# CITY OF ALBUQUERQUE

May 10, 2016

**RE: Desert Ridge Pointe (a.k.a Glendale Townhomes)  
Grading and Drainage Plan  
Engineer's Stamp Date 3-22-2016 (File: B19D028)**

Based upon the information provided in your submittal received 4-25-16, the above referenced submittal cannot be approved for Site Plan for Building Permit until the following comments are addressed:

DESERT RIDGE POINTE  
CONCEPTUAL GRADING & DRAINAGE PLAN

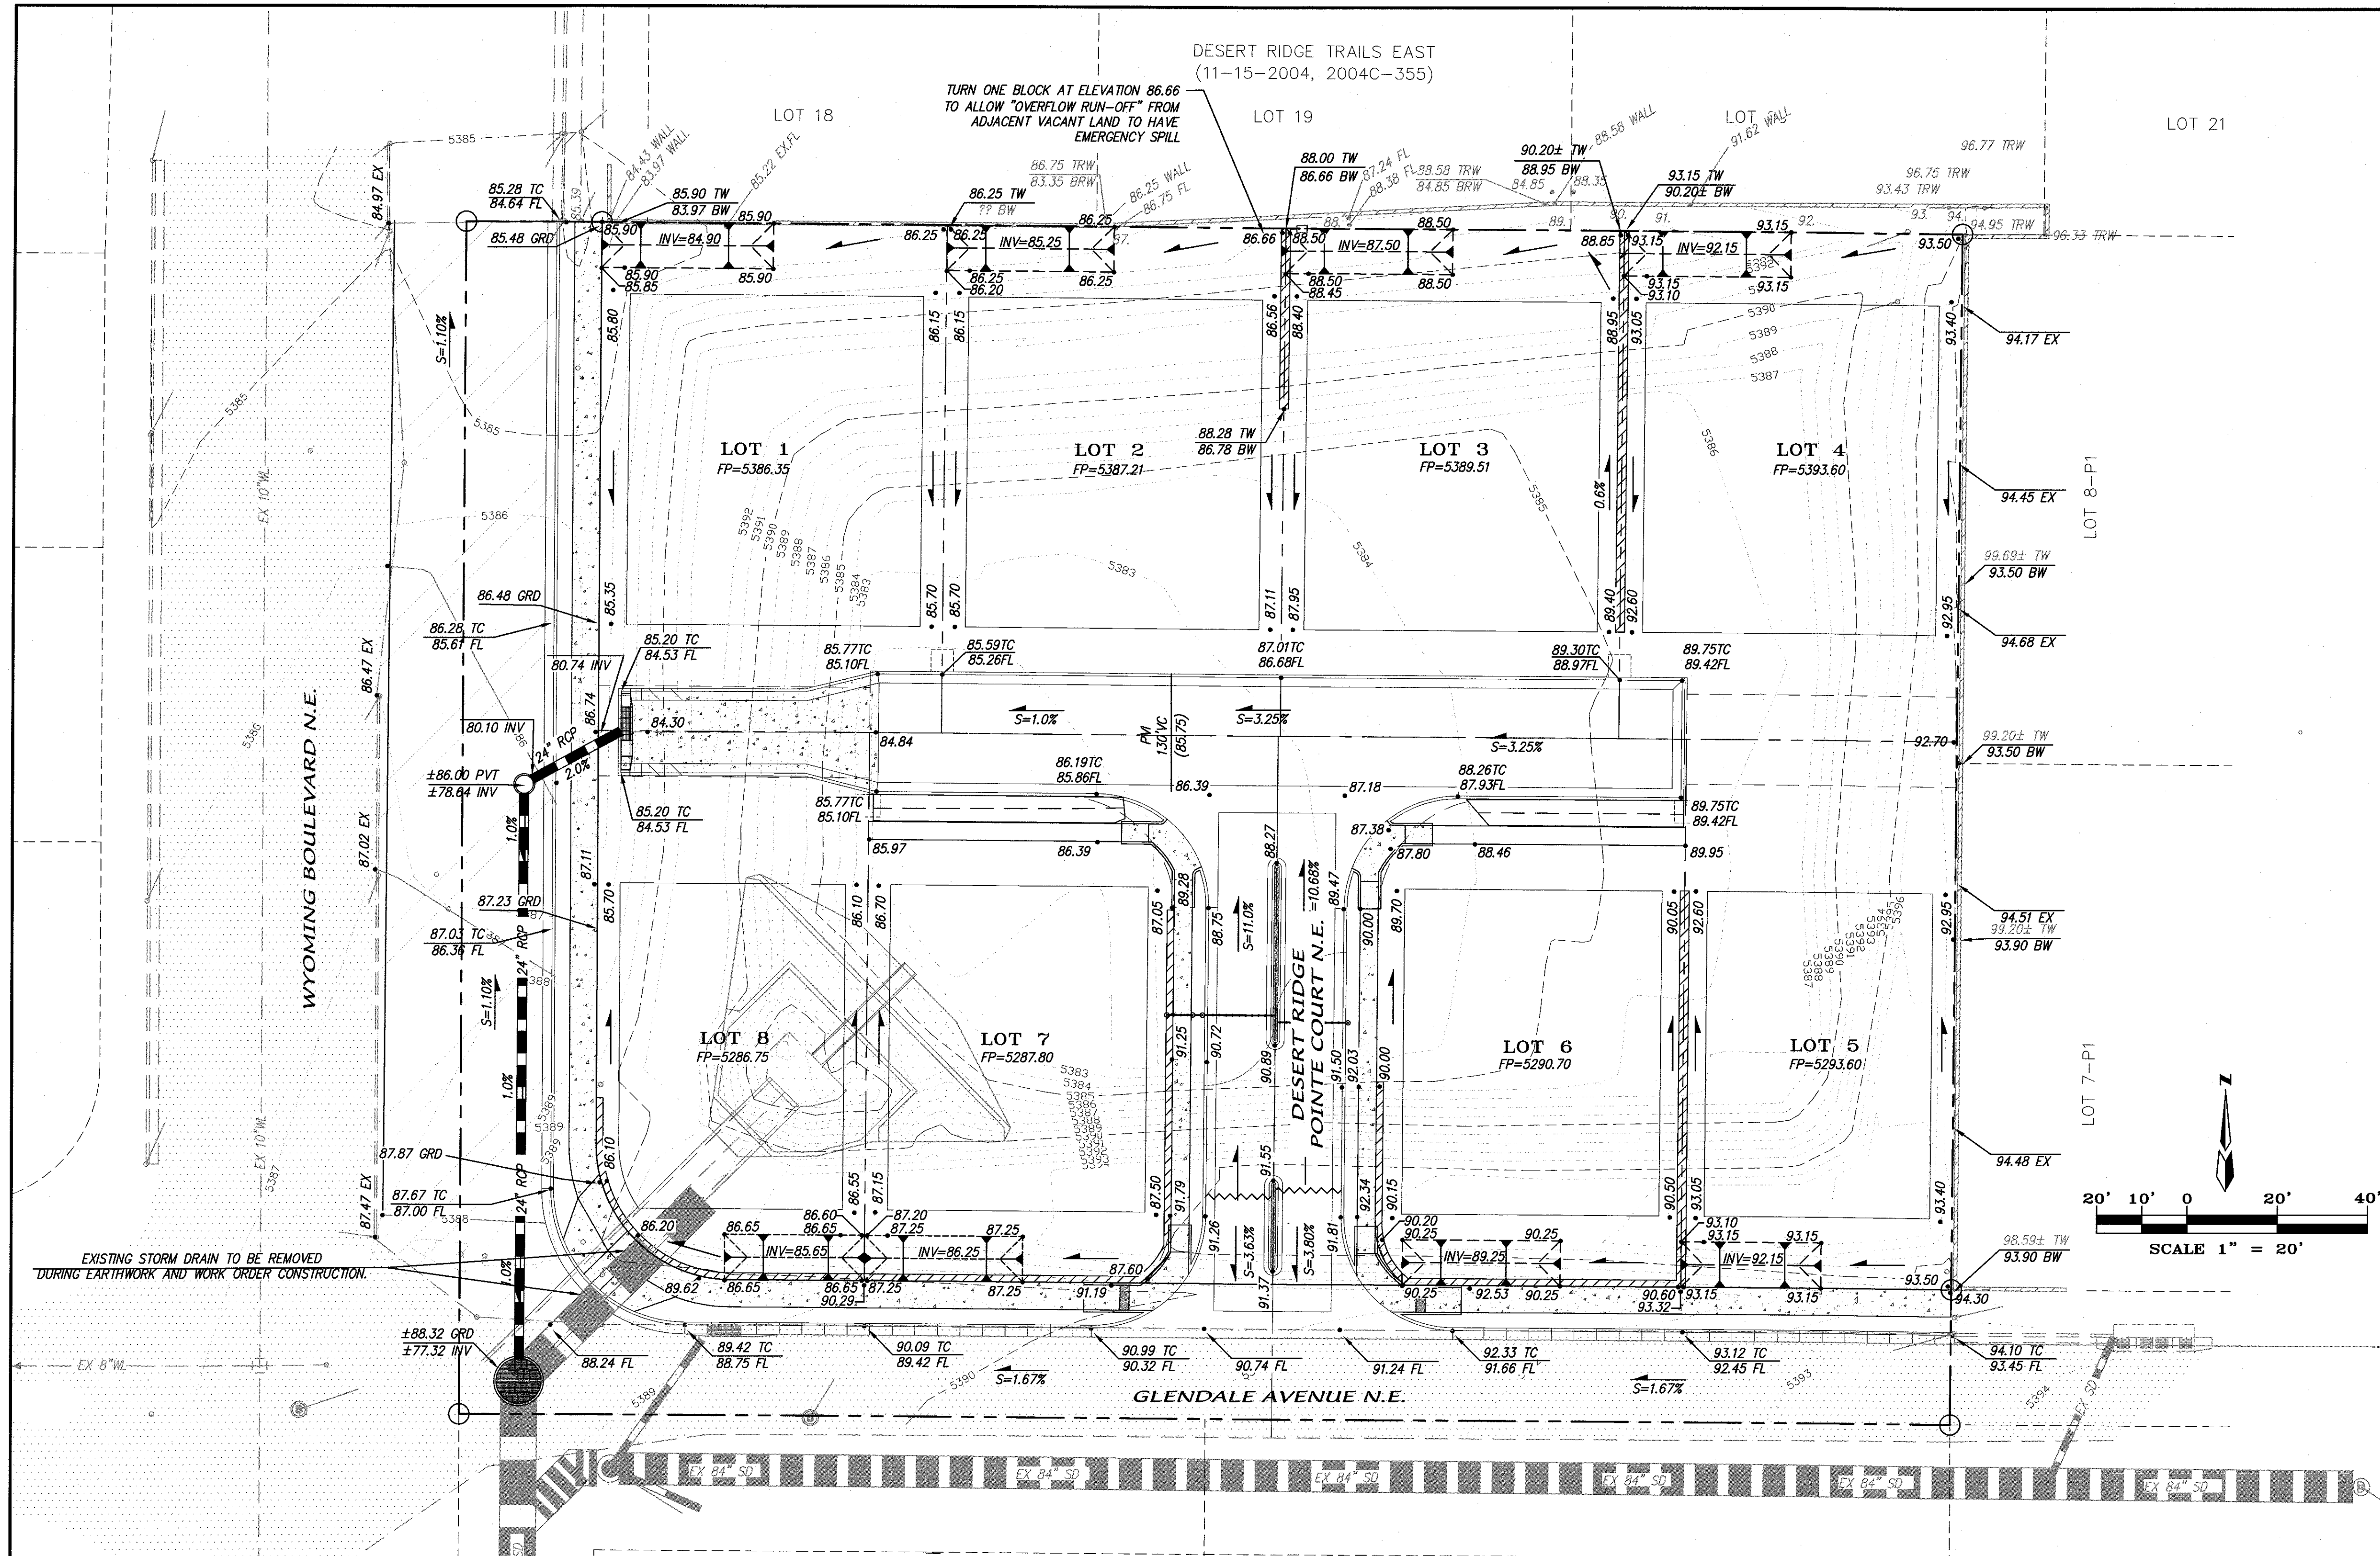
1. Since this site is within Basin 204 of the NAA MDP which discharges to the 96" Storm Drain in Wyoming at Glendale, this site must discharge to this Storm Drain. The outfall shown is a Sidewalk Culvert discharging to Wyoming, and contours show that it would flow north to a different outfall which may not have capacity.
2. The 84" Storm Drain in Glendale is deep, and therefore it is anticipated that a Storm Drain in Wyoming, north of Glendale will have enough fall to tie into the existing system.
3. The land treatments must be limited to those in the NAA MDP. For this basin it was 20% A, 20% B, 34% C, 26% D
4. The First Flush must be addressed.
